# Dean Moor Solar Farm

## Environmental Statement: Appendix 6.4 –Stakeholder Engagement on behalf of **FVS Dean Moor Limited**

March 2025  
Prepared by: Stantec UK Ltd  
PINS Ref: EN010155  
Document Ref: 6.3  
Revision: 1

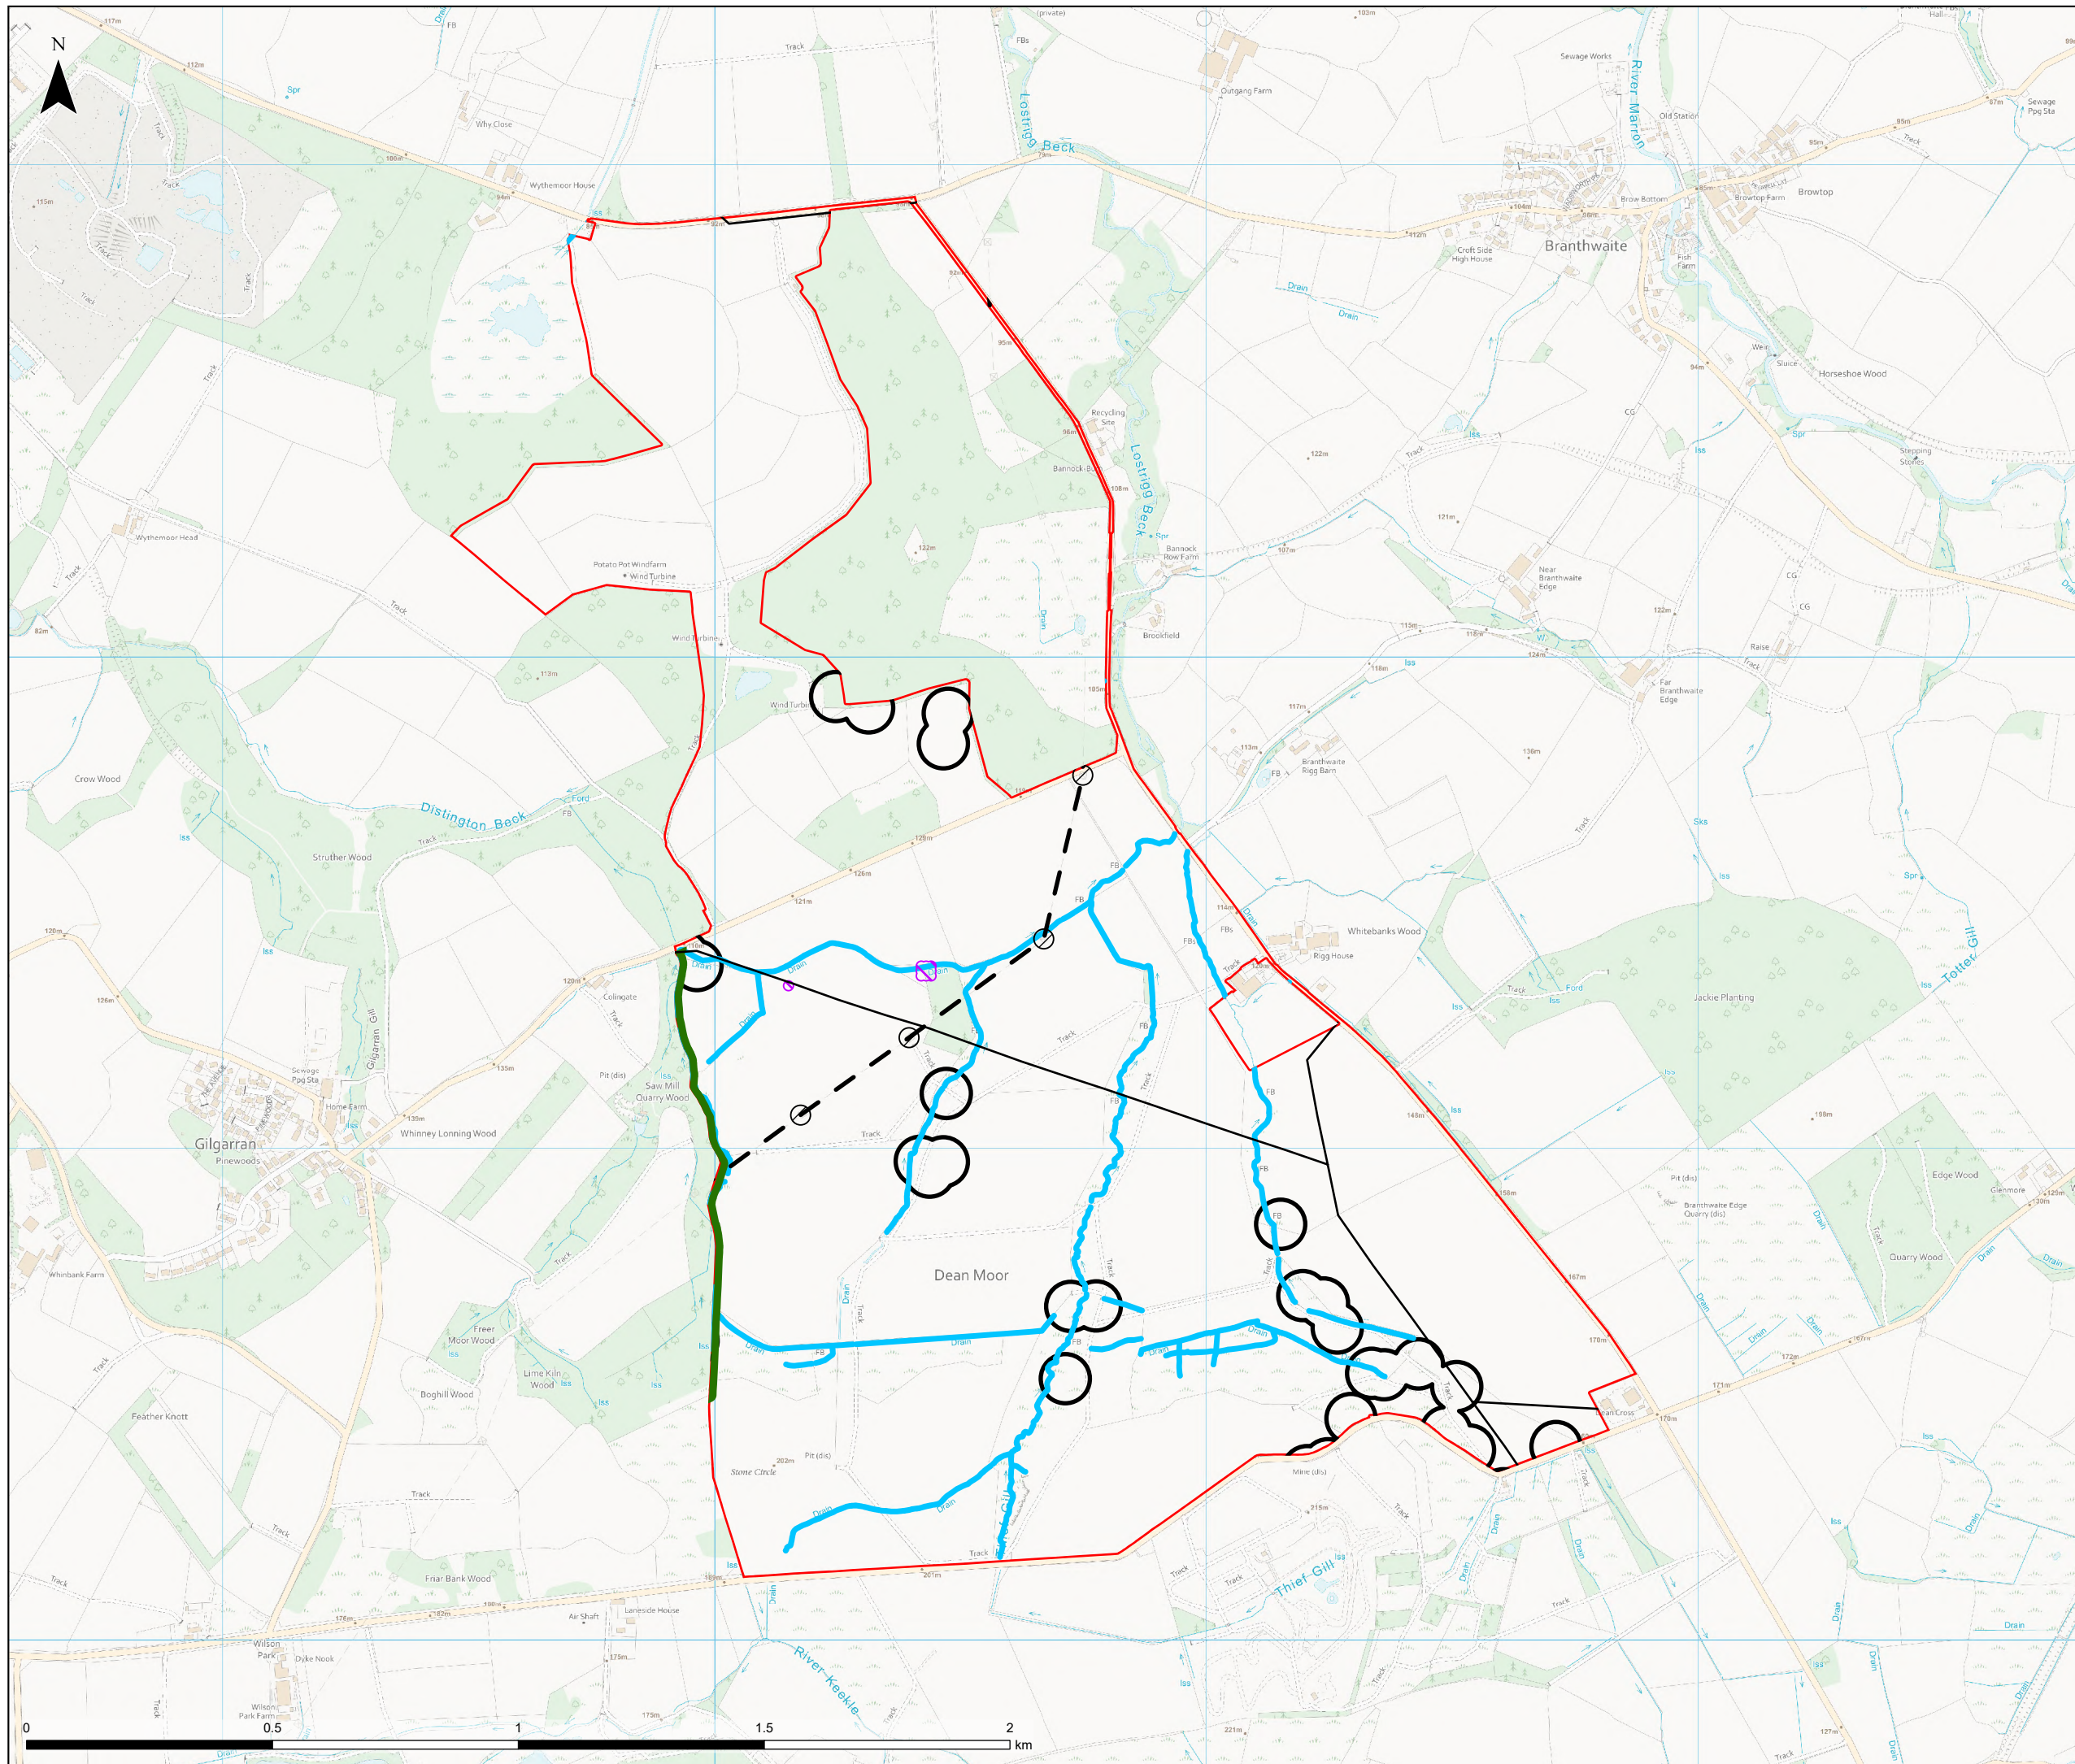
The plan you sent showing the final development scheme has 'solar pv infrastructure' and 'associated infrastructure' covering the peat.

So, I don't understand the reason why you have moved trial trenches located around the peat. I request that additional trenches are added to the area around the peat edge please – they do not necessarily need to extend in to the peat itself if that is a concern – in order to investigate the moderate Bronze Age potential of the site identified in the dba.

Why have these 3 trenches highlighted on the attached plan been removed?

I would much prefer to keep the total number of agreed trial trenches from the previous AMS, which I think was 26 and are absolutely minimal for the large scope of the scheme, and place any removed trenches from exclusion zones in areas of potential around the peat edge instead, please. Does that sound a reasonable approach to you?

Unfortunately, I don't understand why some agreed trenches have been omitted as they look to me to not be located within exclusion zones. I wonder whether you would be able to overlay the exclusion zones on the trench plan please, so that I may see why trenches have been removed?

If you're certain that the exclusion areas will not be impacted upon during the construction work then by all means amend the mitigation scheme. If cables or machinery are likely to cross the exclusion zones, or if there will be other construction impacts within the exclusion zones, then it would best to leave mitigation scheme as it is. I suggest it would be preferable to agree the mitigation scheme before the DCO submission.

Thanks [REDACTED] – I've shifted these around to the edge of the peat – please see attached – this gives us the coverage.

Hi [REDACTED] – its due to a concatenation between the exclusion zones and the results of the detailed peat survey (results below – this is still a draft). Simply put the area and composition of peat is further defined than we had from the Phase 1 report / BGS data.

Peat with thicknesses of 0.46m bgl to 2.1m bgl was confirmed very locally in two distinct locations which are both within the area indicated as peat on BGS mapping. To minimise the impact on peat at the Site (as excavation of peat can lead to carbon losses/emissions), the areas have been avoided of solar PV infrastructure.

Considering this, we can tighten up the scope in response to the localised pockets of soft soil/peat. However, where encountered in the two locations, A von Post classification of the two localised areas of peat encountered showed it to be H9 indicating that the peat is practically fully decomposed.
